CITY OF ALBUQUERQUE
PLANNING DEPARTMENT
DEVELOPMENT REVIEW BOARD

July 24, 2002

10. Project #1002090
Application # 02DRB-01066
Lands of Hindi, Tracts A-1, A-2 and A-3

PLAT
 OF
TRACTS A-1, A-2 AND A-3
LANDS OF HINDI
 SECT. 17, T10N, R3E, NMPM
 ALBUQUERQUE, BERNALILLO COUNTY, NEW MEXICO
 JULY, 2002

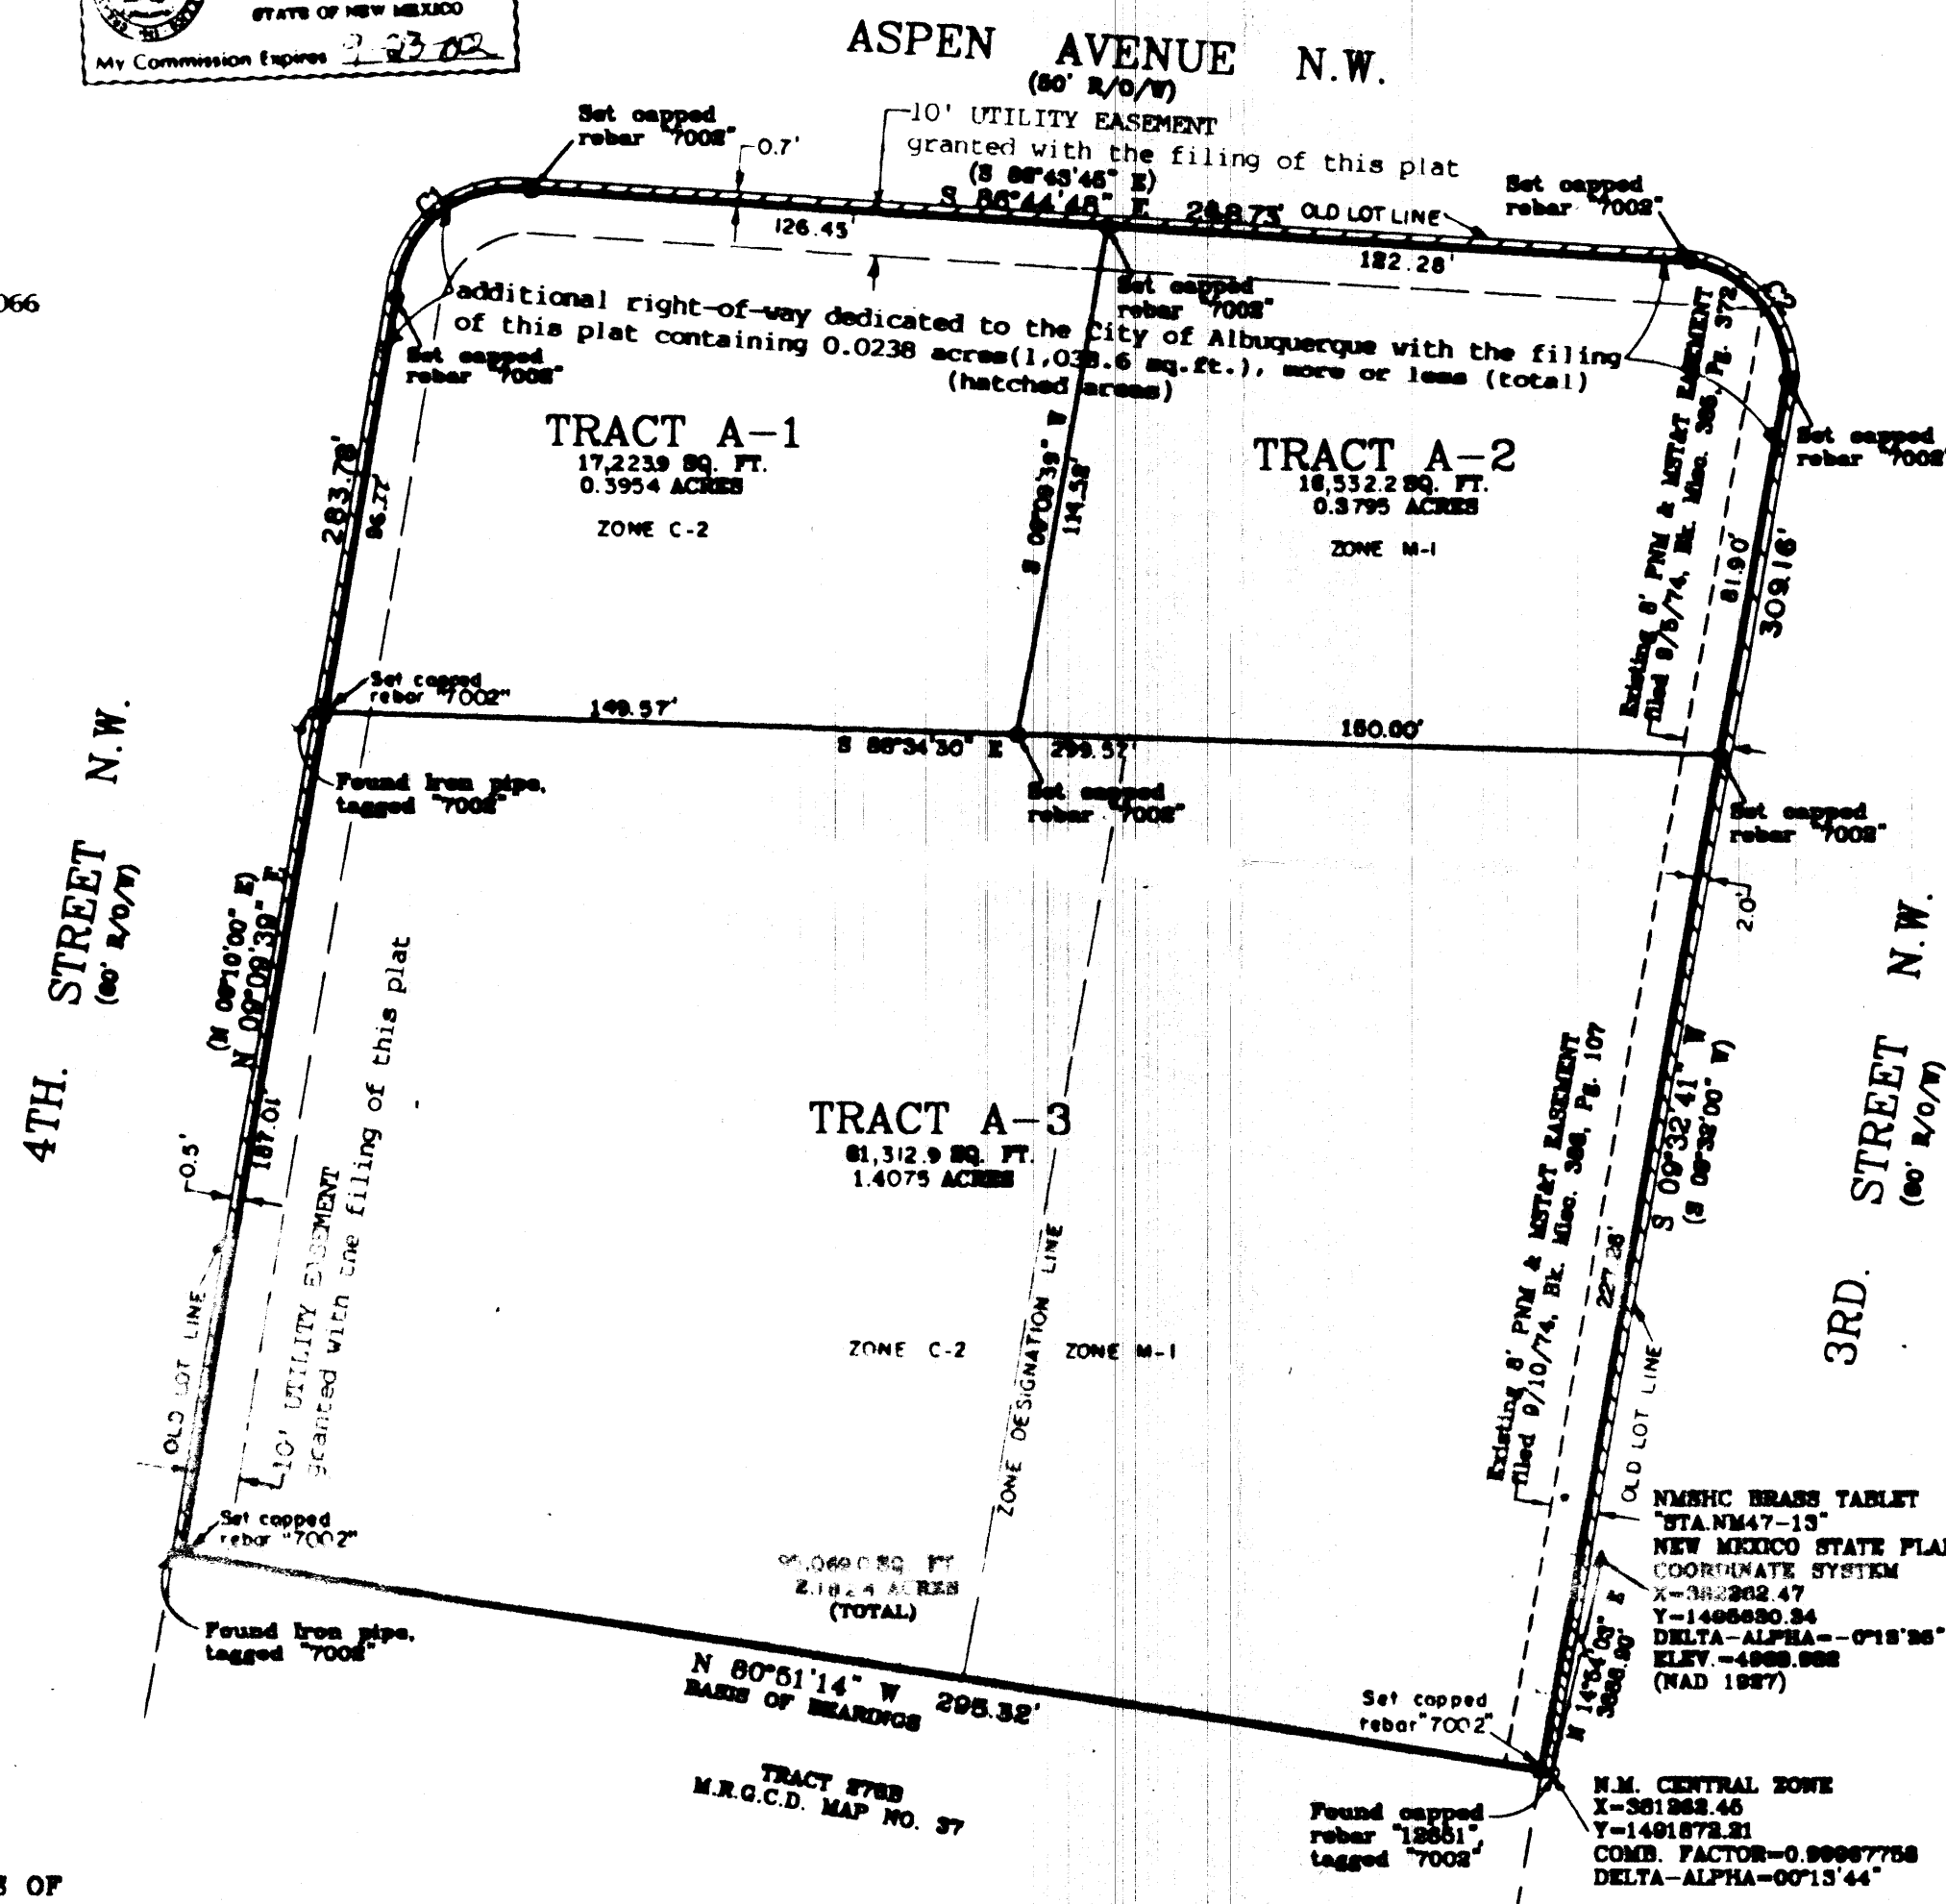
1. In reviewing the zone lines shown in the City's geographic information system, it appears the proposed plat will split the zone line, i.e. the west half of Tract A-3 would be zoned C-2 and the east half would be M-1. Zone lines and plat lines should be concurrent. Please review and revise as necessary.

2. Include the Project # and Application # on the plat.
3. Specify which tracts are zoned C-2 and which tracts are zoned M-1 on the plat under the "Notes" section.

No.	Comment
<input type="checkbox"/>	Dedication of right-of-way to provided 10 feet from the face of curb to the property line is needed along all the perimeter streets.

PLAT
 OF
TRACTS A-1, A-2 AND A-3
LANDS OF HINDI
 SECT. 17, T10N, R3E, NMPM
 ALBUQUERQUE, BERNALILLO COUNTY, NEW MEXICO
 JULY, 2002

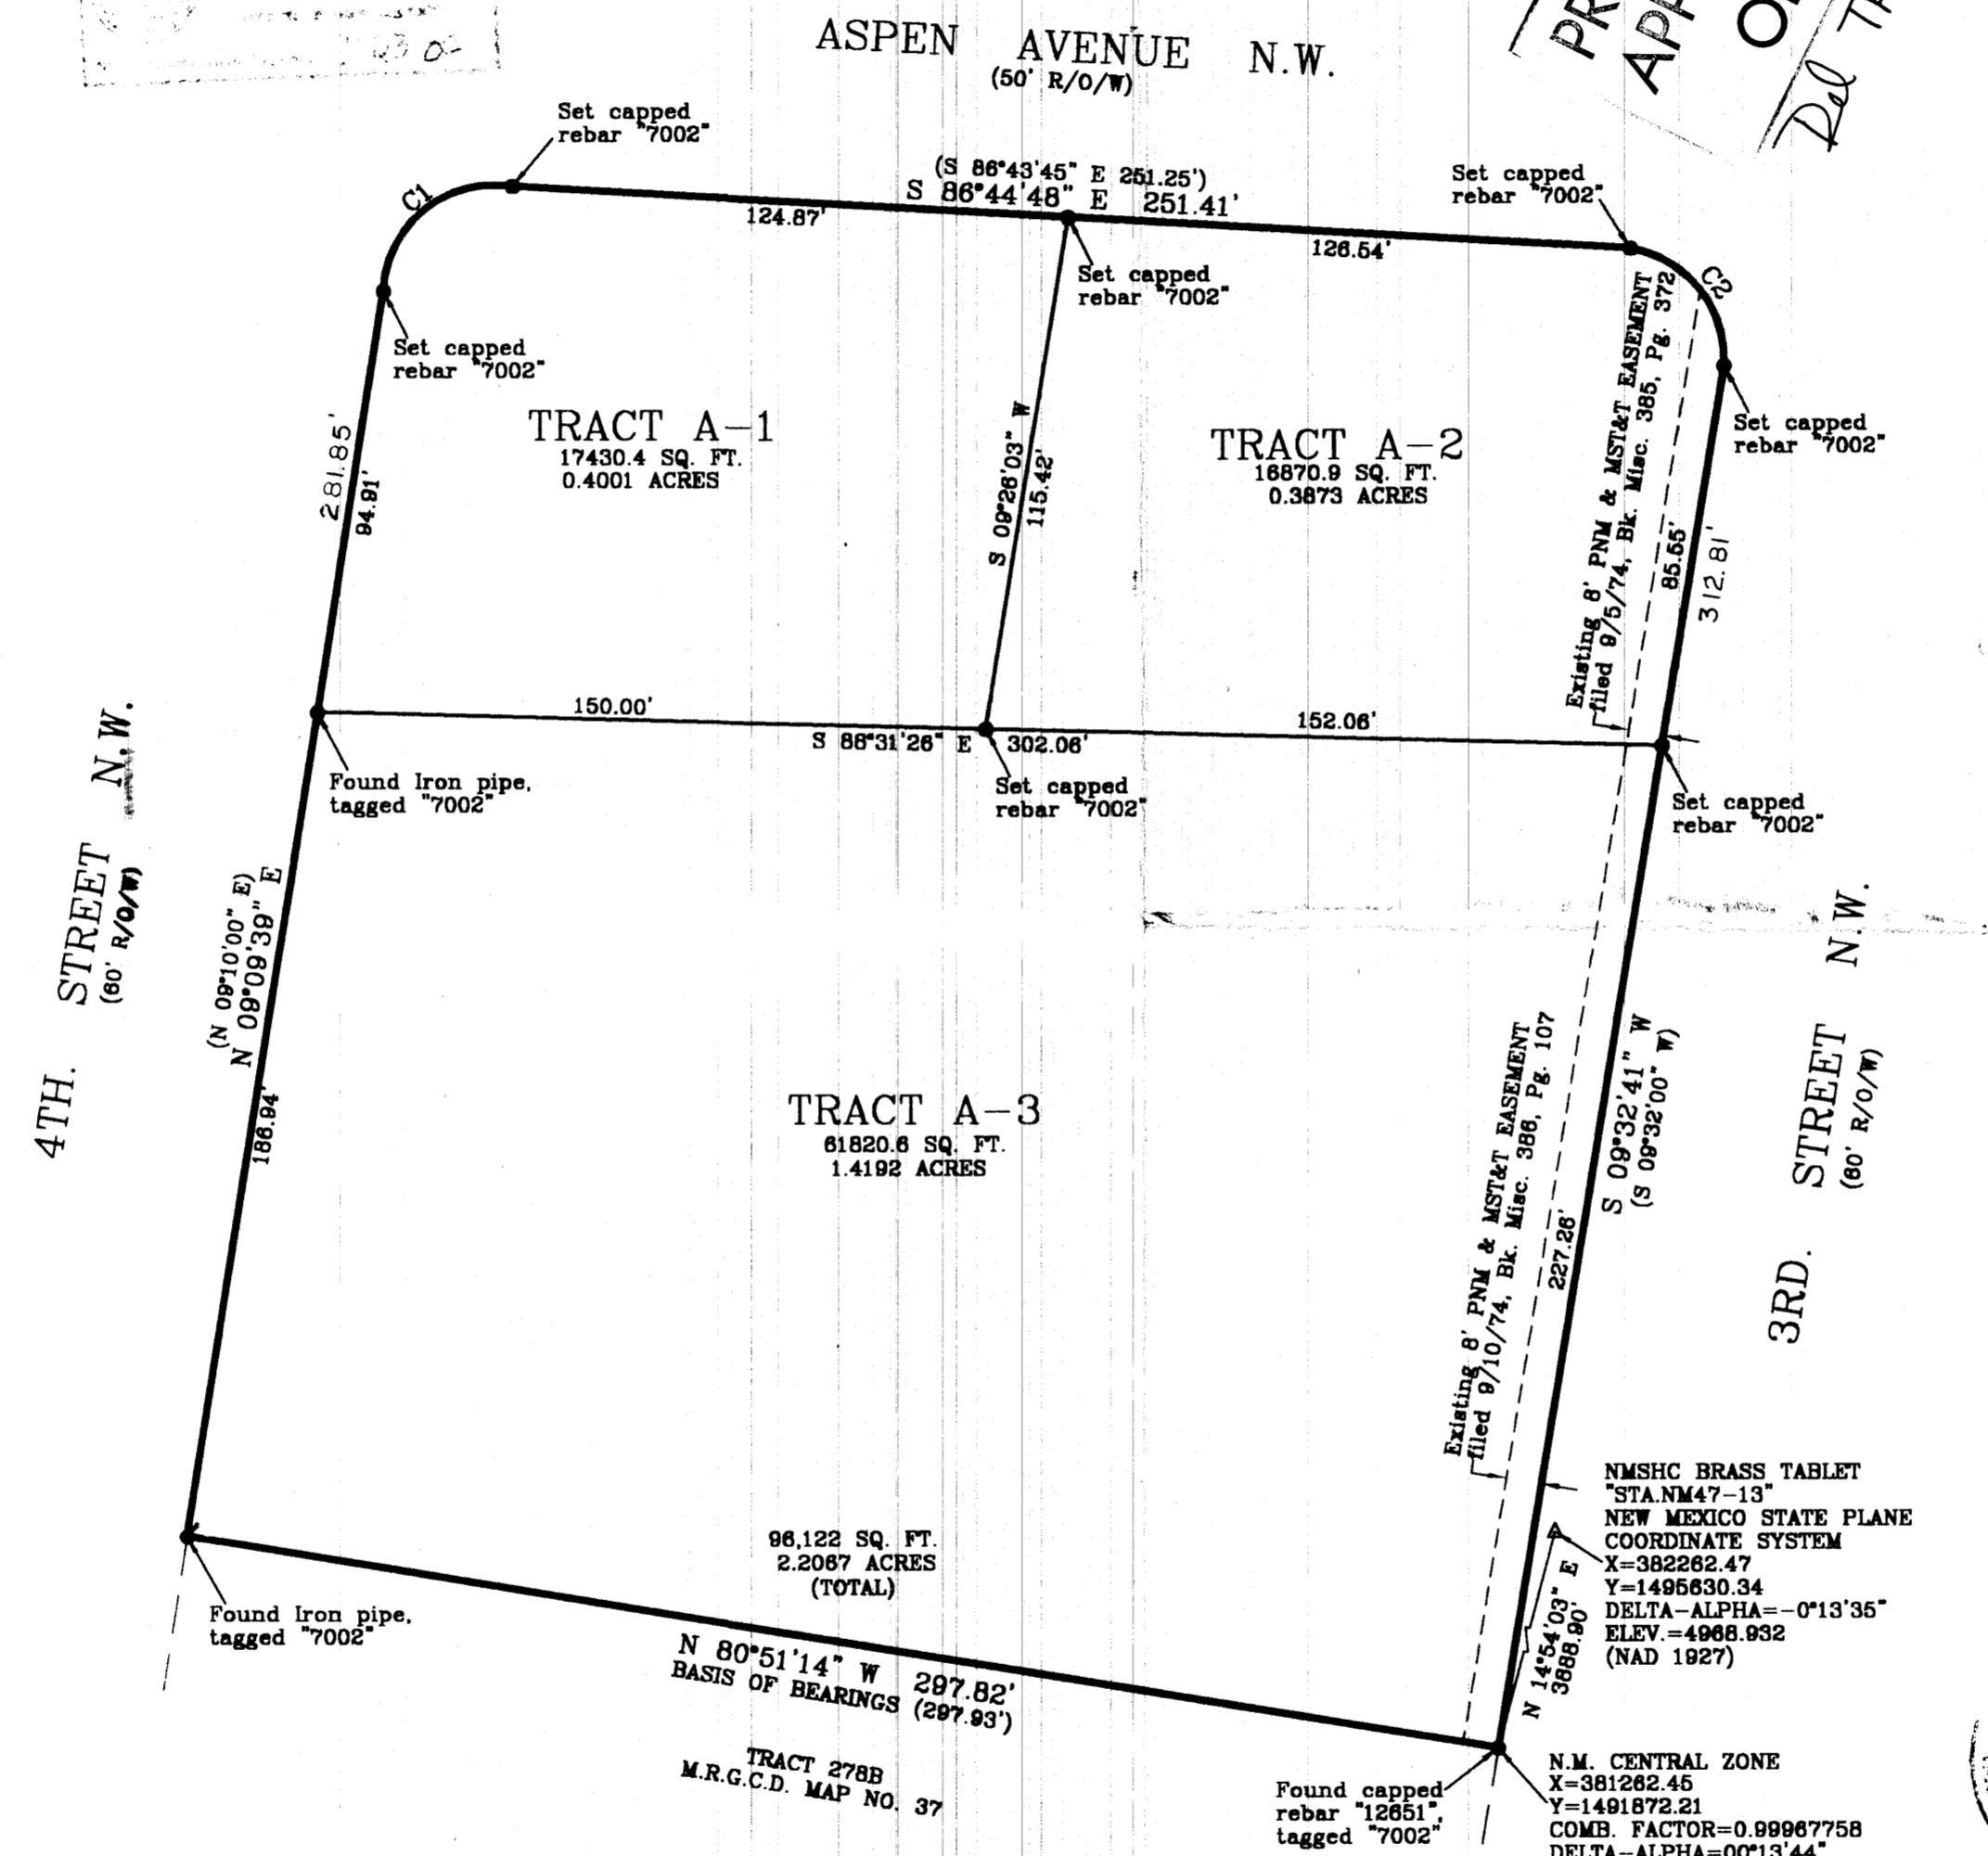
7. Please provide a digital dxf file showing parcel, right-of-way and easement lines in New Mexico State Plane Feet, NAD 1927. This information will be forwarded to AGIS.
